Major Projects – State Significant Infrastructure
Snowy 2.0 – Transmission Connection Development Application (SSI-9717)

Thank you for providing the NSW Environment Protection Authority (EPA) with the opportunity to provide comment on the Environment Impact Statement (EIS) for the proposed Snowy 2.0 Transmission Connection (the Project). The EPA understands that the Project will connect the proposed Snowy 2.0 pumped hydro and generation project (the Snowy 2.0 project) to the existing high voltage transmission network.

The EPA has reviewed the EIS for the Project and provides detailed comment and recommendations in **Attachment A**.

Figure 2-3: Indicative substation layout

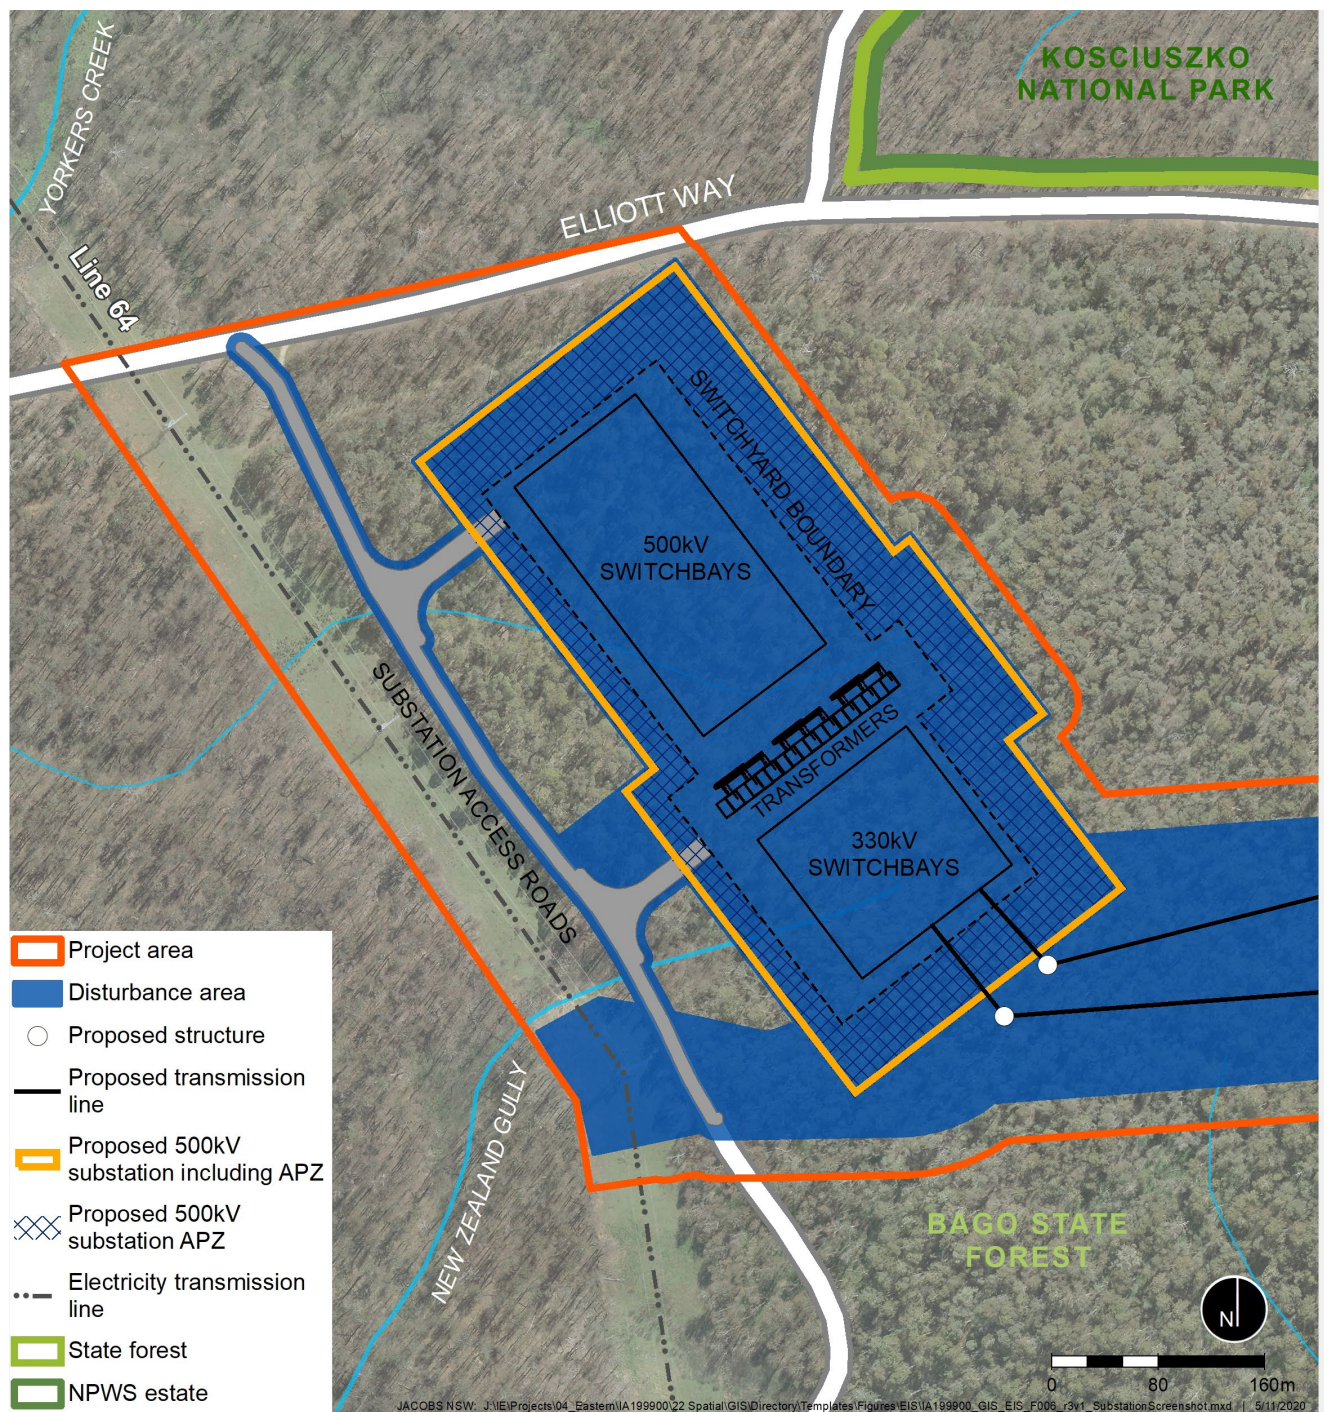
The EPA considers that the management of water generated within the substation is unclear. The EIS provides a general statement that there will be no discharges other than water applied for dust suppression. The EIS also identifies that water used for the testing of the spill oil containment system at the substation site would be captured and treated on site. It is unclear how the water captured during testing will be managed, if and where it will be discharged to, or what the quality of the discharged water would be.

It is also unclear how stormwater captured during routine operation will be managed. There has been no characterisation of the stormwater discharge, and it is unclear if the substation site will store materials/equipment that may leach pollutants (e.g. old transformers/capacitors that could leach PCBs).

The EPA recommends that the Proponent provide further information on the management of the spill containment system and stormwater at the substation.

- 1. characterises the expected quality of the discharge in terms of the concentrations and loads of all pollutants present at non-trivial levels;***
- 2. provide details of any onsite water treatment measures;***
- 3. provide details of the stormwater pit size(s) and the rainfall events that the stormwater pits are designed to accommodate;***
- 4. provides the frequency and volume of site discharges under a range of scenarios such as commissioning, typical and worst case;***
- 5. assesses the potential impact of the proposed discharge on the environmental values of the receiving waterway with reference to the relevant ANZECC guideline values; and***
- 6. where the discharge has potential to cause non-trivial harm, assess practical measures to avoid, minimise or mitigate impacts to the downstream receiving environment.***
